WHIPPLE-CALLENDER ARCHITECTS

MEMORANDUM 4.10.13

RE: 145 Glenwood Ave

Clarification request

1 Second Floor Plan
SCALE: 1/4" = 1'-0"

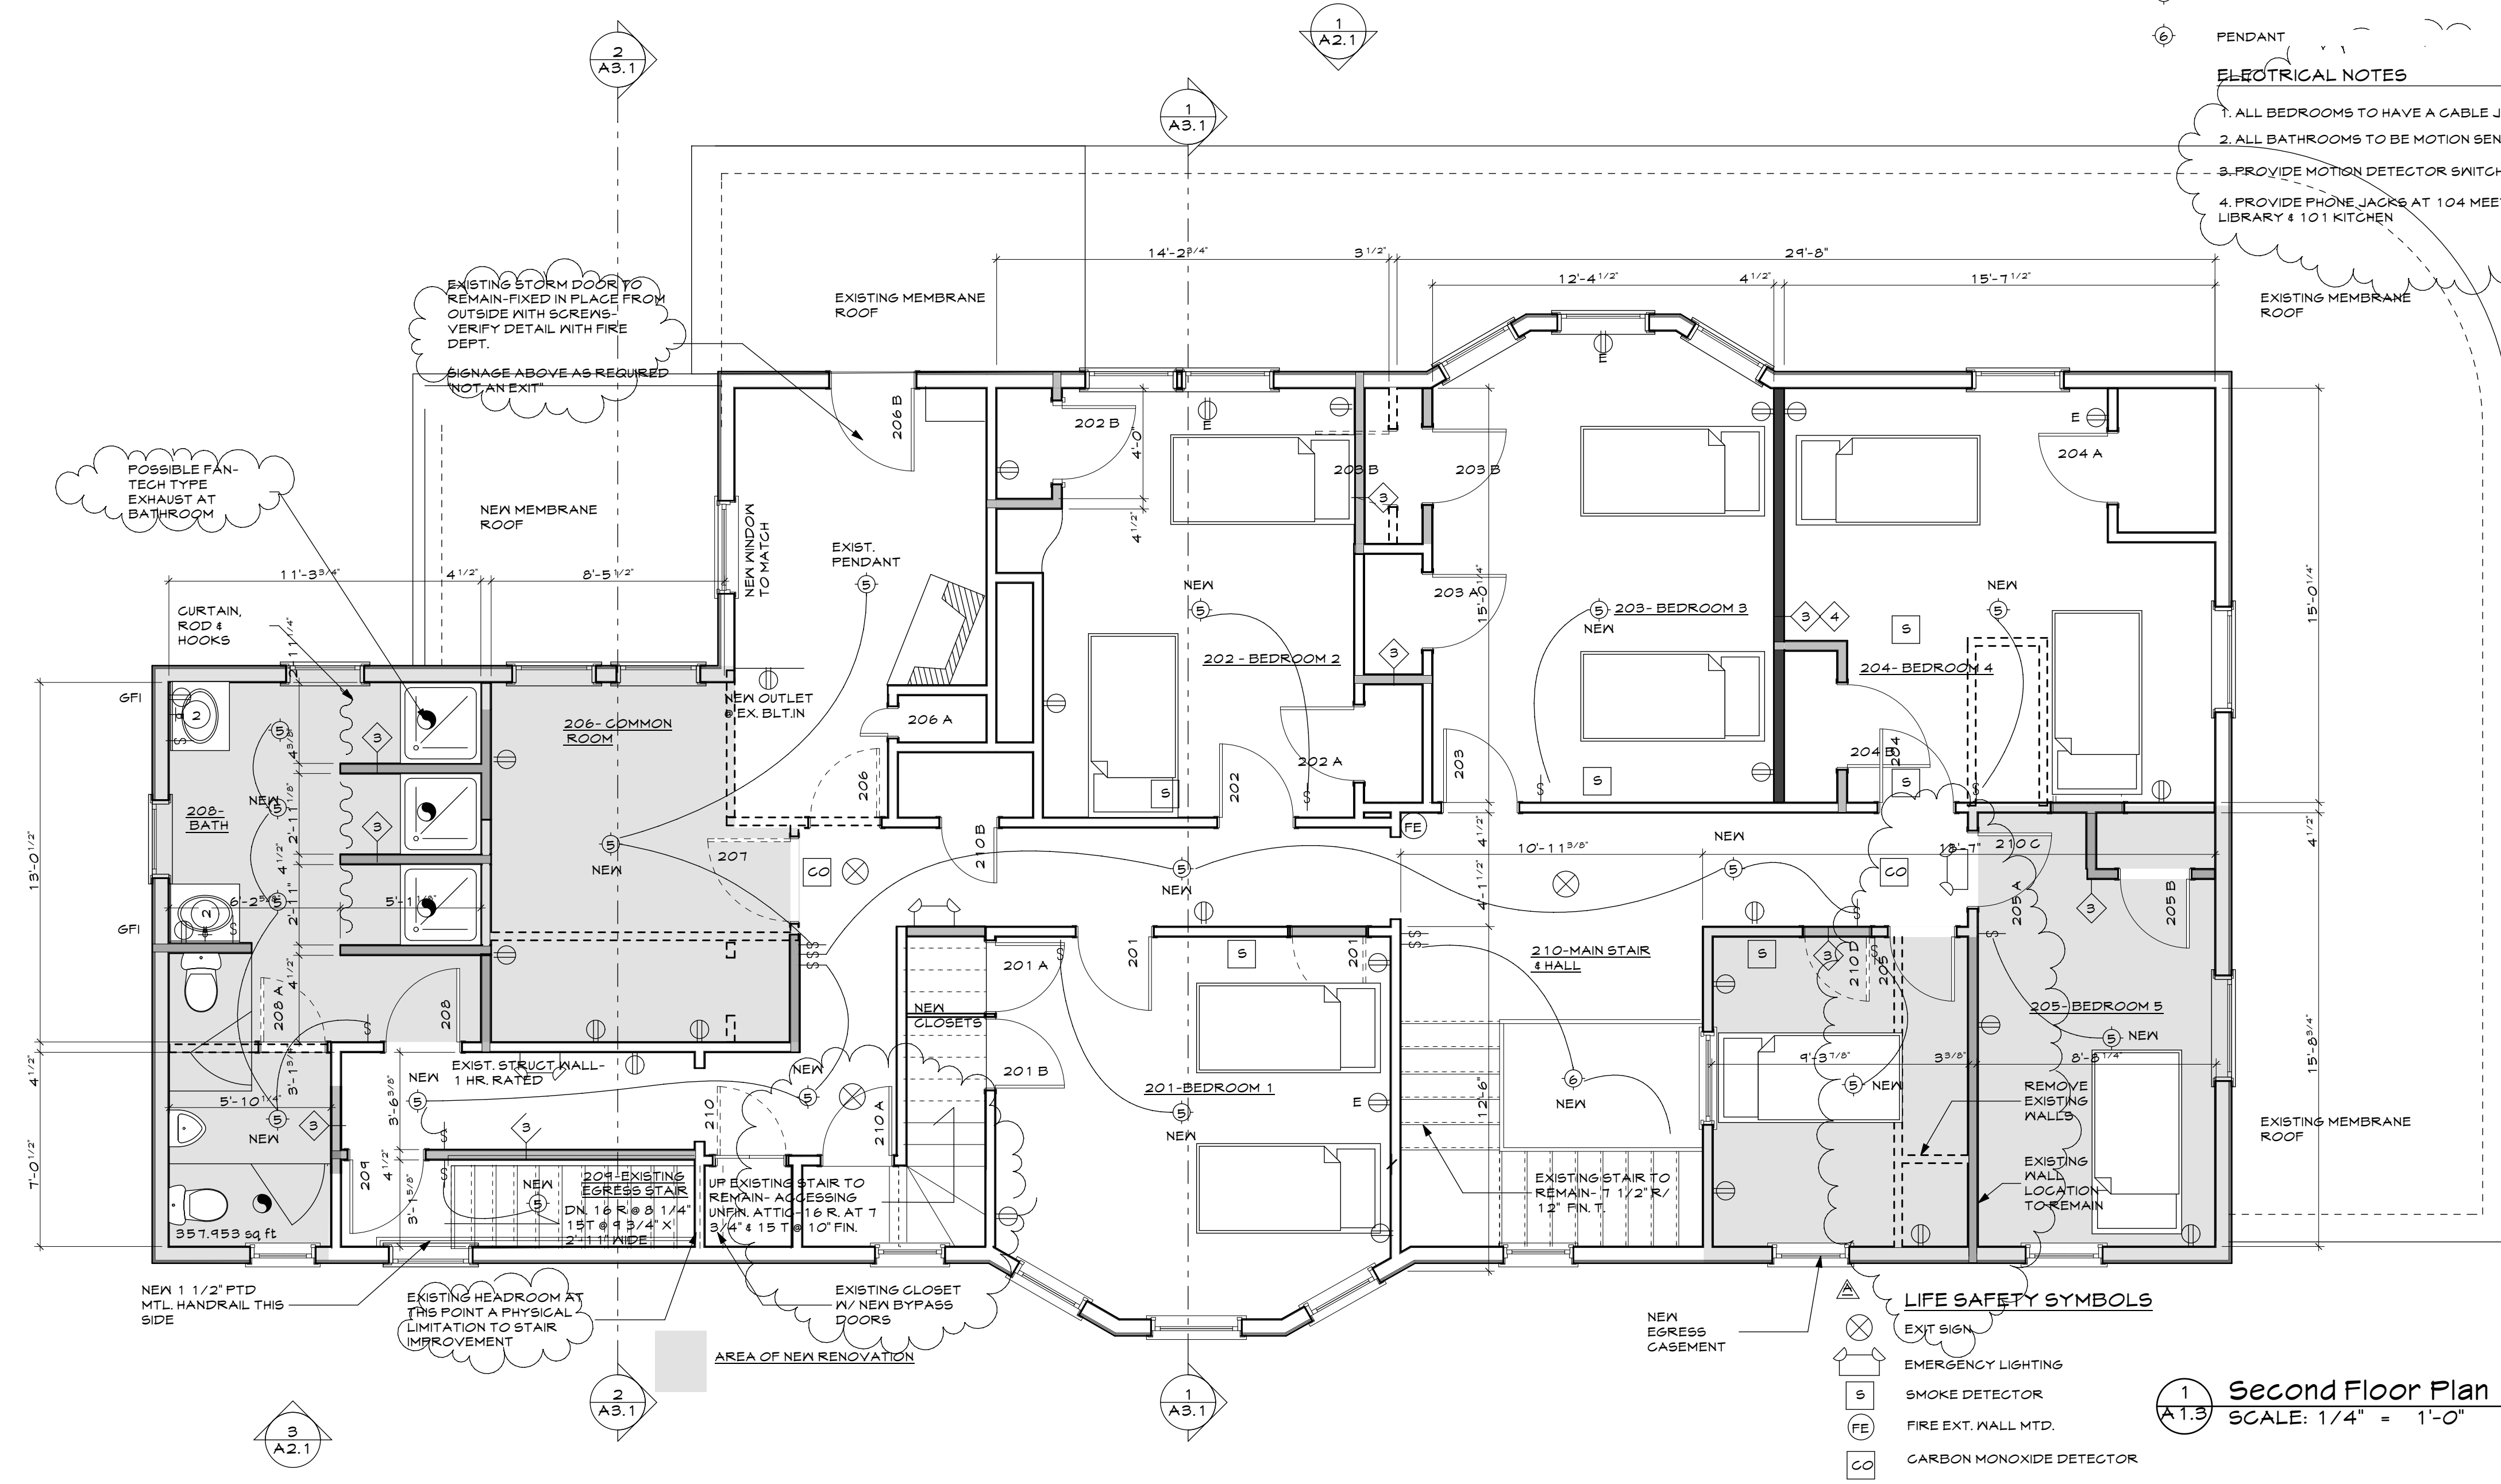
1. Door 209 to egress stair 209 will be a 20 min. rated door.
2. Partition type 3 is a one hour rated partition, 5/8" sheetrock ea. side, U.L. 359.
